CITY OF ALBUQUERQUE

August 19, 2021

RE: 1701 Soplo Rd SE
Permanent C.O. – Not Accepted
Engineer's Stamp Date: 03/14/19
Engineer's Certification Date: 08/18/21
Hydrology File: N23D001

ENGINEER'S SEAL  3/14/19 DAVID SOULE P.E. #14522	1701 Soplo Road S.E.	DRAWN BY: WCUJ
	GRADING AND DRAINAGE PLAN	DATE: 3-14-19
	 Rio Grande Engineering 1606 CENTRAL AVENUE SE SUITE 201 ALBUQUERQUE, NM 87106 (505) 872-0398	219019-LAYOUT-3-14-19 SHEET # JOB # 219019

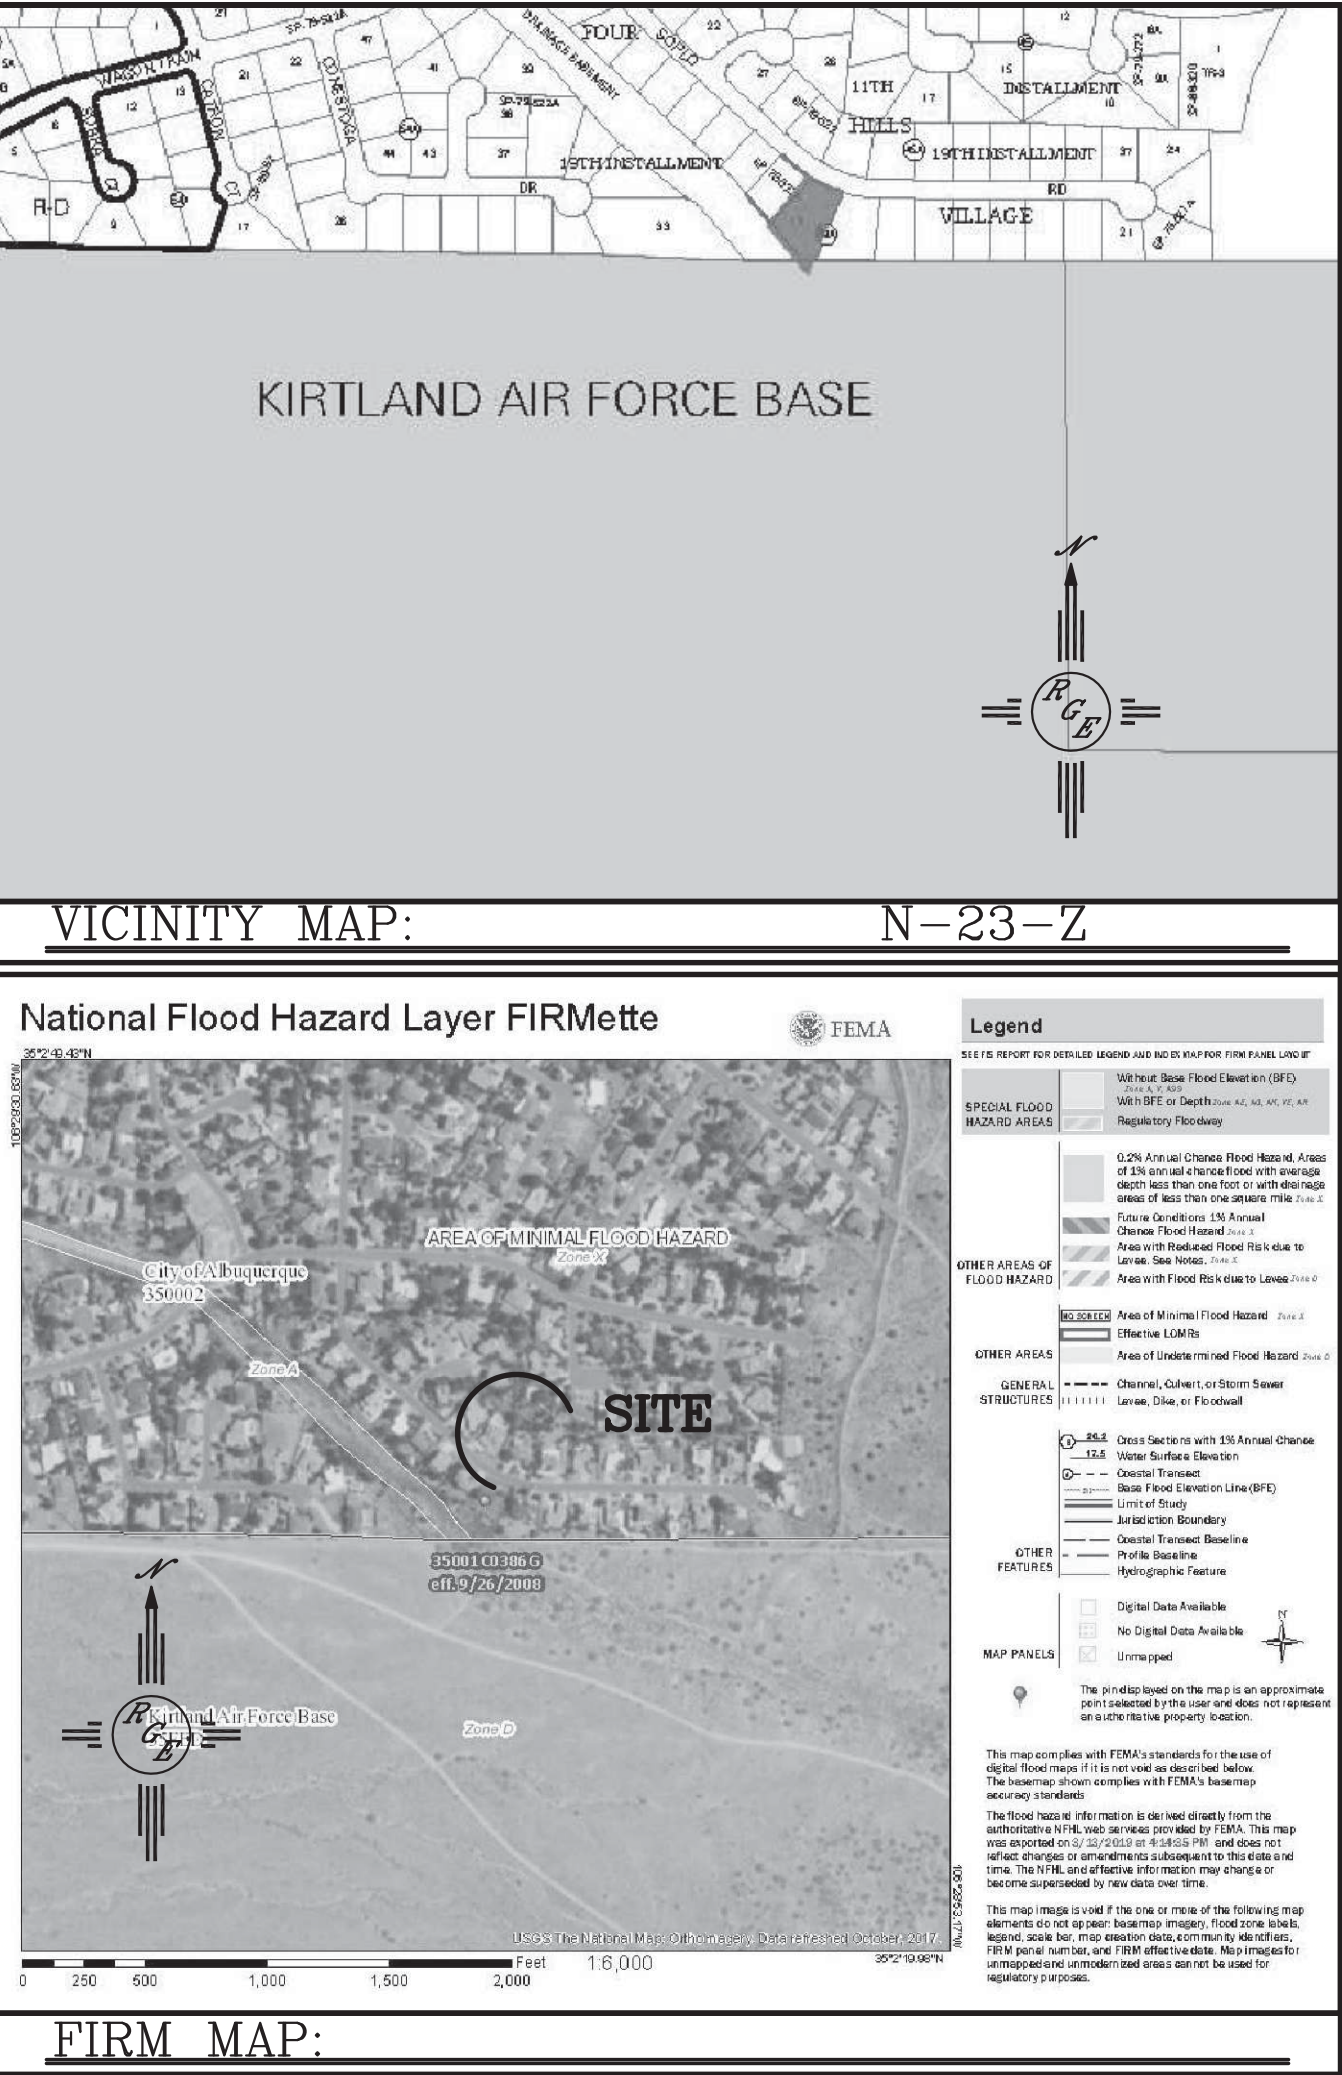
1. The retaining wall was built within both the 10 foot Drainage Easement along the Southwest property line and the 20 foot Drainage Easement along the South property line. The wall also was installed on top of the sour protection for the Four Hills Arroyo and some of it was removed with this installation. (See image below).

- a. The removal of the retaining wall within both Drainage Easements, re-establish the grades within the easement to pre-development conditions, and reestablish the sour protection for the Four Hills Arroyo. **Please note that the built location of the retaining wall was not approved by Hydrology.** During the wall permit process, the plan reviewer just looks to see if the Grading & Drainage Plan in the permit set was the approved plan.
- b. An engineering study to show that the remaining sour protection is able to handle the approximately 1200 cfs of the Four Hills Arroyo and get this approved by Hydrology. Then both Drainage Easements can be vacated through the Development Review Board (DRB). Once the vacation has been approved, then Hydrology will be able to approve this certification for Permanent Release of Occupancy.
